SITE AT LINGARDS ROAD - PROPOSED HOUSING			
CLIENT - S.B. HOMES LIMITED			
William Best RIBA		SITE SECTIONS A, B, C	
The Chapel House, 22, Pole Gate, Scammonden, West Yorkshire, HD3 3FW. Tel 01484 845896 Mob 07828 461144		SCALE	DATE
		1:200 WB	17/01/2020
		2019-572-13 G

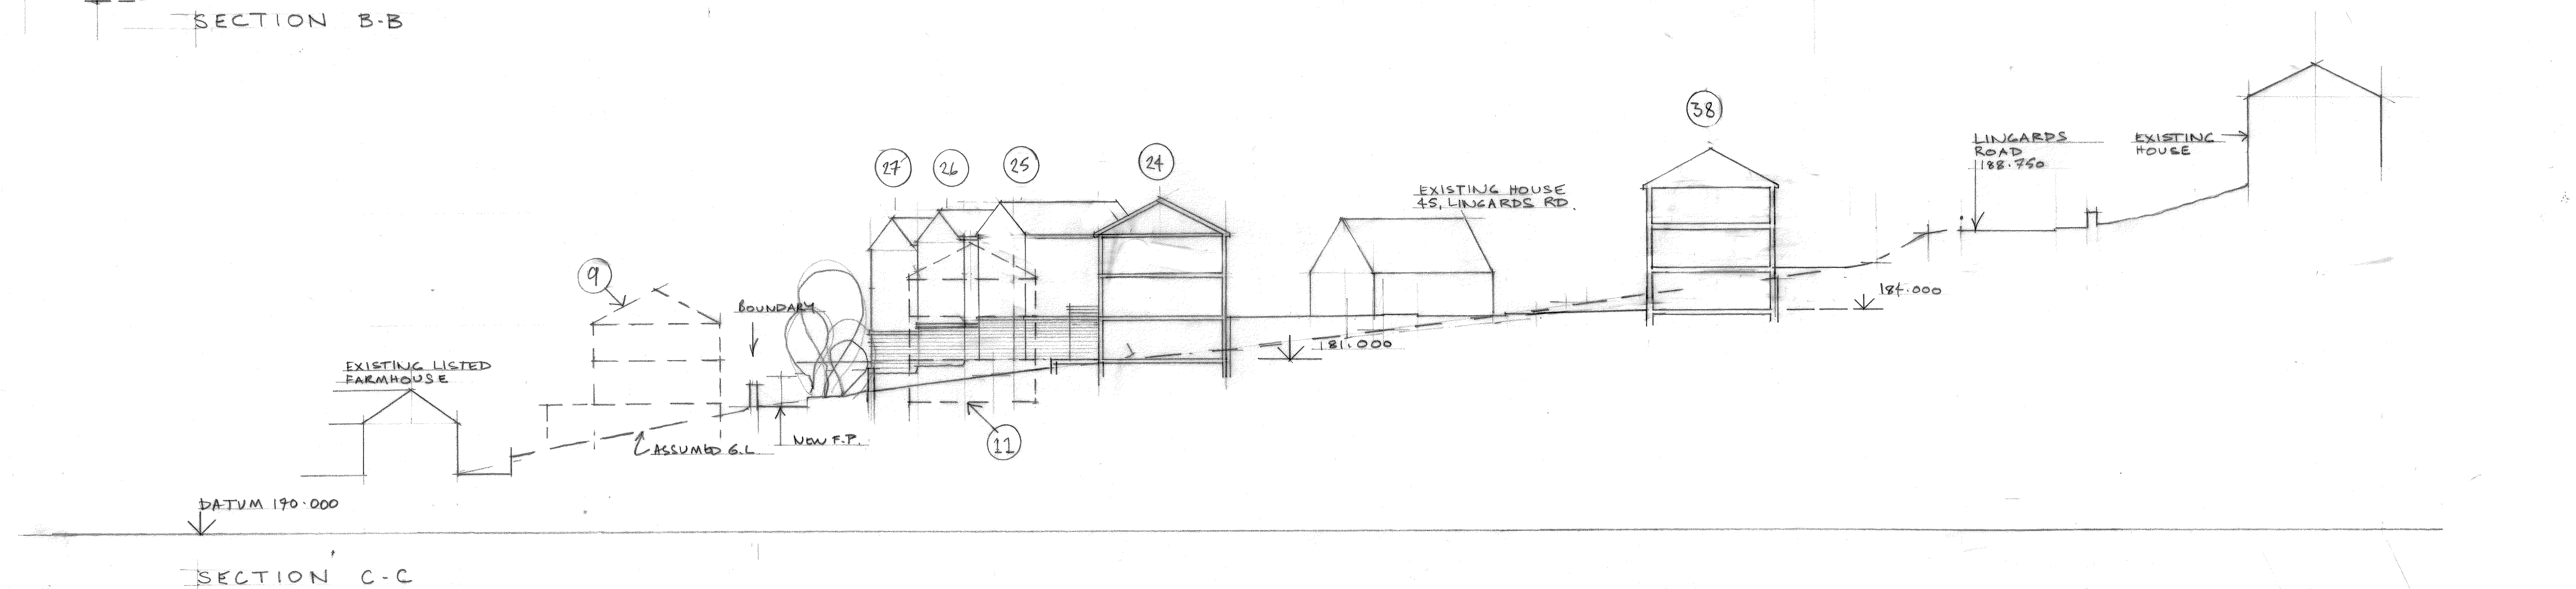
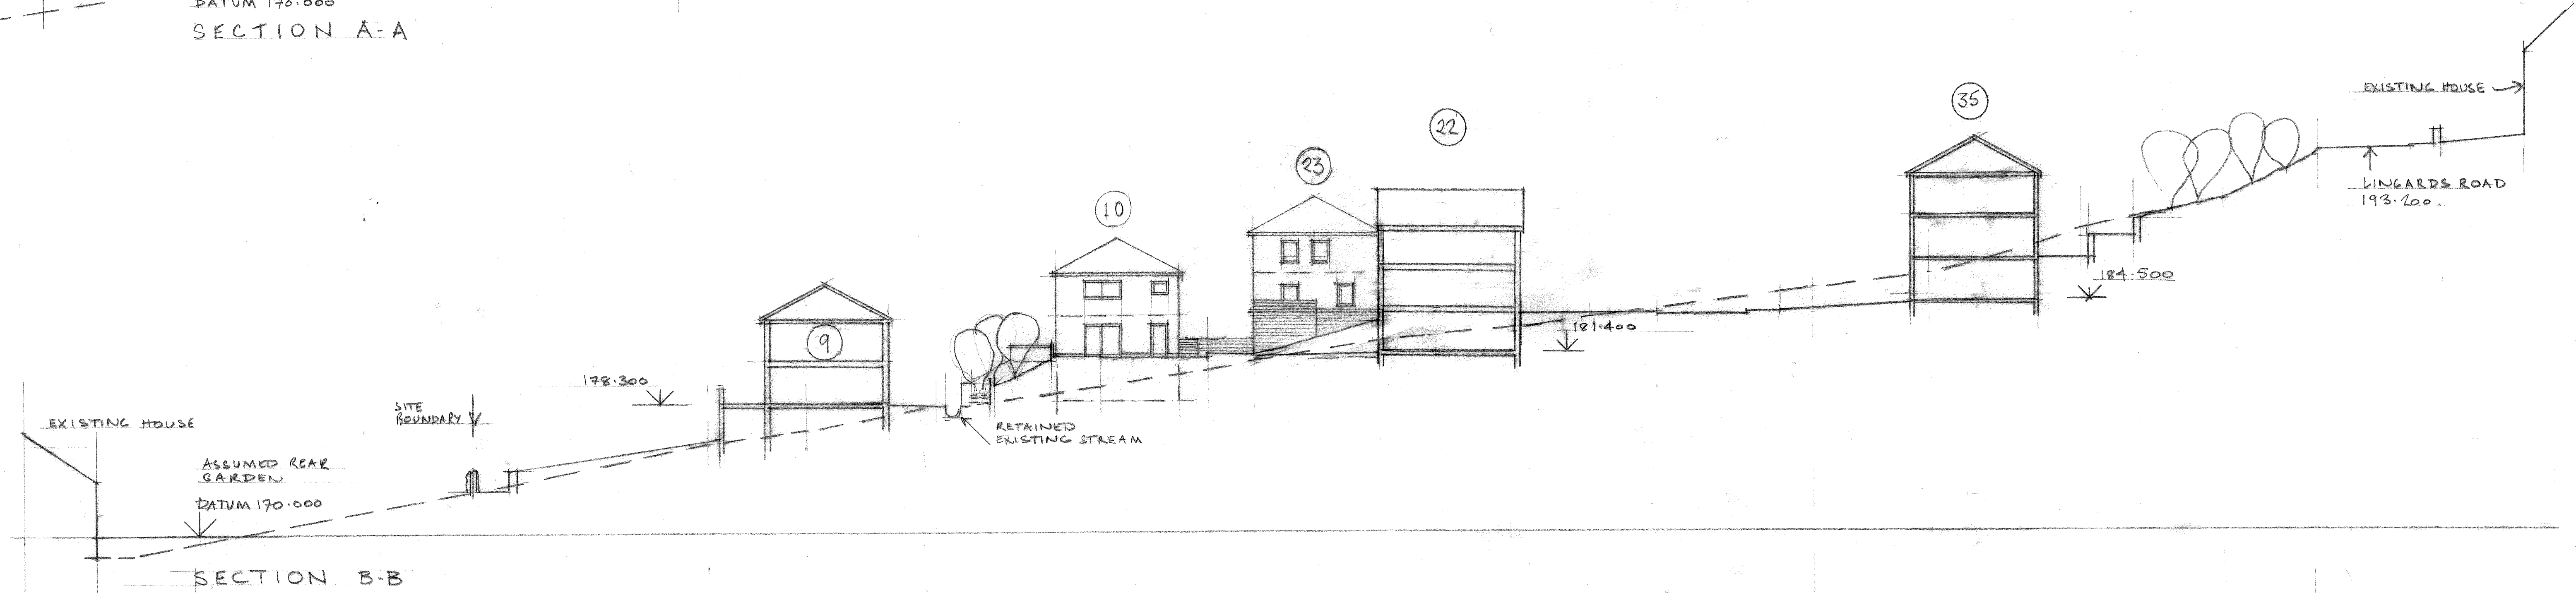
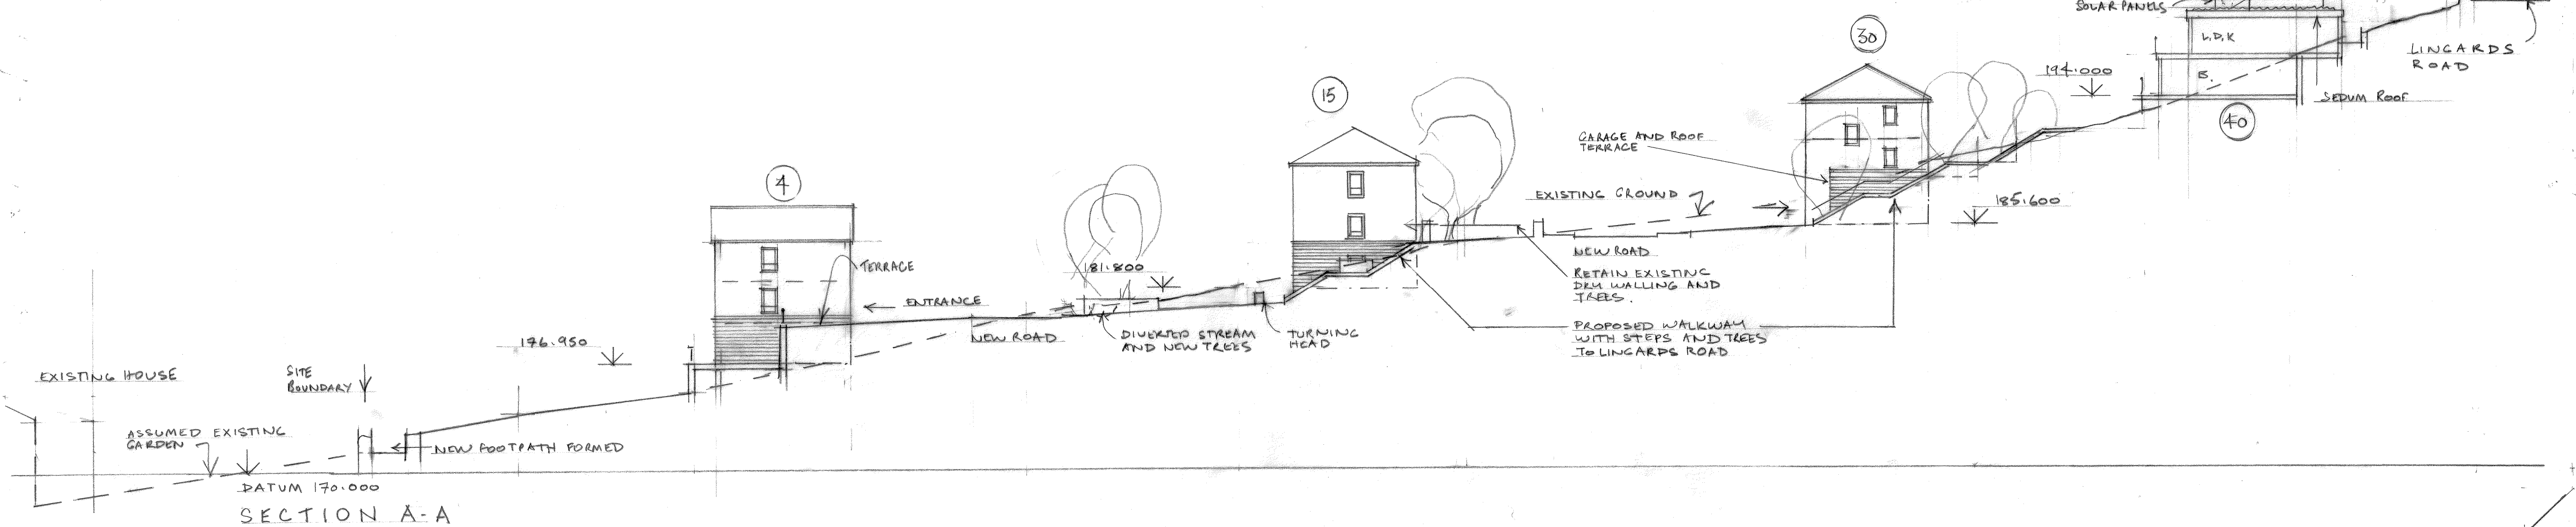
Building three storey properties on this development site is intrusive in terms of privacy, and also within the landscape. Making it much worse is the fact that the developer proposes to build the site up so that two storeys of these properties will be above Lingards Road and directly opposite the existing houses above the development site. This means the privacy of the existing properties above the development site will be severely compromised as well as being oppressive and mean loss of light. It will also compromise the privacy of the new residents. The narrowness of the road and the decision to have the minimum 21m as the distance between the current homes and the new homes across exacerbate this. It is interesting that the developer on his plan gives a much larger distance.

It seems that the whole tiered plan proposed compromises virtually everyone's privacy above and below the new development as well as those living within the new development. The inclusion of balconies and wide windows in the new properties exacerbate this further.

It does not seem to make sense to build up in this way. To reduce the impact on people's privacy, the plan should be considering keeping things as low as possible.
